10-13-23

Re: Broadway Apartments
314 Broadway SE
Traffic Circulation Layout
Engineer's/Architect's Stamp -no stamp- (K14D232)

Based upon the information provided in your submittal received 10-3-23, the above referenced plan cannot be approved for Building Permit until the following comments are addressed:

SHEET NO.
TCL
DATE:
9/26/23

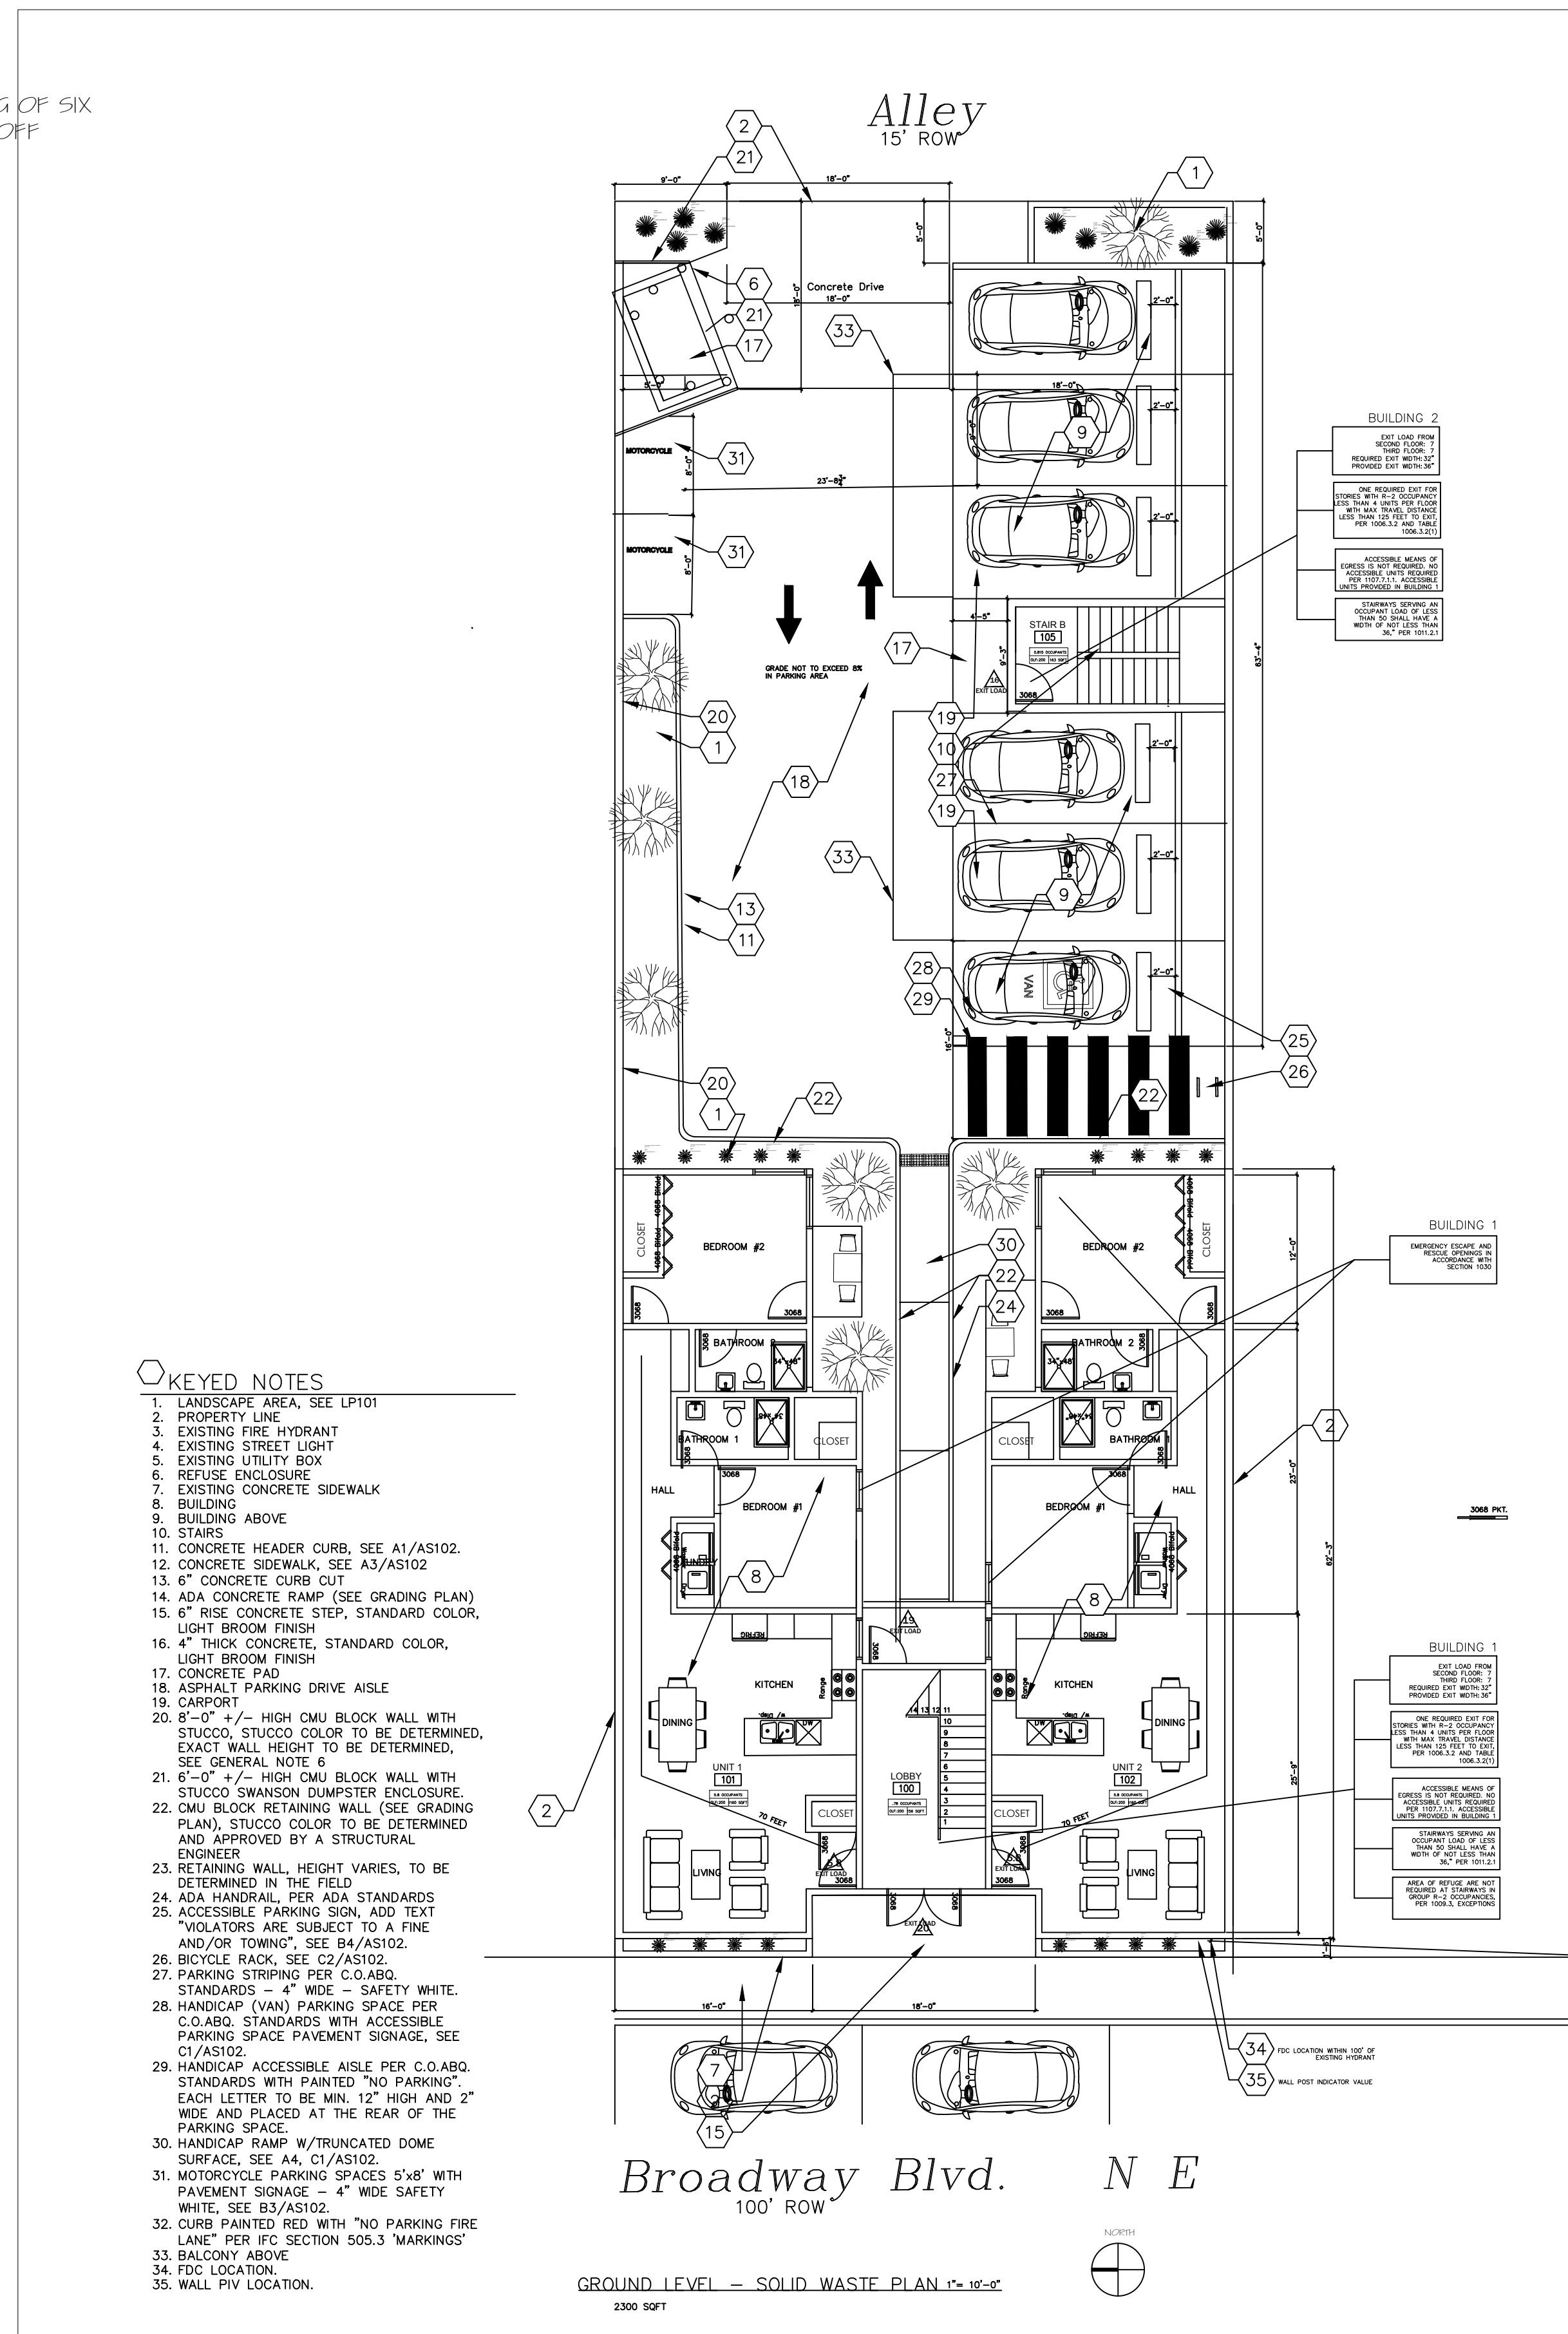
4. Please show the existing drivepad on Broadway (that will need to be closed) as well as the alley that is used for access. Show the alley to either Lead Ave or Silver Ave as it will have to be paved. Your site is closer to Lead Ave, so it may be beneficial to use Lead Ave for access.

5. Provide the alley width along the frontage of the project site.
6. The alley paving, closing of the existing drive entrance on Broadway Blvd, constructing sidewalk and curb and gutter in the location of the closed driveway and all other improvements in the ROW will be done through the City's Work Order process. Indicate this on the plan (e.g. Alley to be paved by Work Oder). Contact Jim Roeder in DRC: jroeder@cabq.gov, 924-3992.

7. Provide a dimension for the width (face of curb to middle of stripe) of the parking spaces on Broadway Blvd.
8. Provide detail sheets referenced in the keyed notes, except for LP101.

9. An ADA accessible path is required from the Broadway ROW to the door on Broadway Blvd. Clearly show the pathway and details.
10. Required Drive aisle width is 22 ft. The width appears to be less than 18 feet at the dumpster enclosure. Provide drive aisle width at: dumpster enclosure, MC parking and west of stairwell B.

11. There is a space on the plans south of the cars. Is this for storage? If the parking spaces were moved south into this area, it would help widen the drive aisle.

12. Provide the width of the MC parking.

13. Provide the dimensions for the parking stalls and the ADA Van Access.
14. Provide a dimension for the overall site width.
15. The pavement markings for the ADA access aisle should be blue diagonal stripes. See below.

16. The parking spaces appear to have a parking bumper, but a keyed note or similar would make it clearer.
17. The note for the grade in the parking lot not to exceed 8% needs clarification as the ADA space, aisle and path to the ramp can't have a grade steeper than 2%.

18. Provide the ramp slope for the ramp and the width of the ramp, keyed note 30.
19. Motorcycle parking spaces shall be designated by its own conspicuously posted upright sign, either free-standing or wall mounted.

20. Provide dimensions for the concrete header curb: begin, end and distances to changes in direction. In addition, provide the radii for the bends.
21. Does the landscape area in the SE corner have header curb around it?

22. Show the clear sight triangle and add the following note to the plan: "Landscaping and signage will not interfere with clear sight requirements. Therefore, signs, walls, trees, and shrubbery between 3 and 8 feet tall (as measured from the alley edge) will not be acceptable in the clear sight triangle.

23. The drafting standard for text is a minimum of 0.1" height. Dimension text is difficult to read.
24. Please remove the line work for the balcony/upper story to help clarify the parking area. It is not clear what the line behind the cars represents.

25. Provide line work/hatching for the concrete drive.
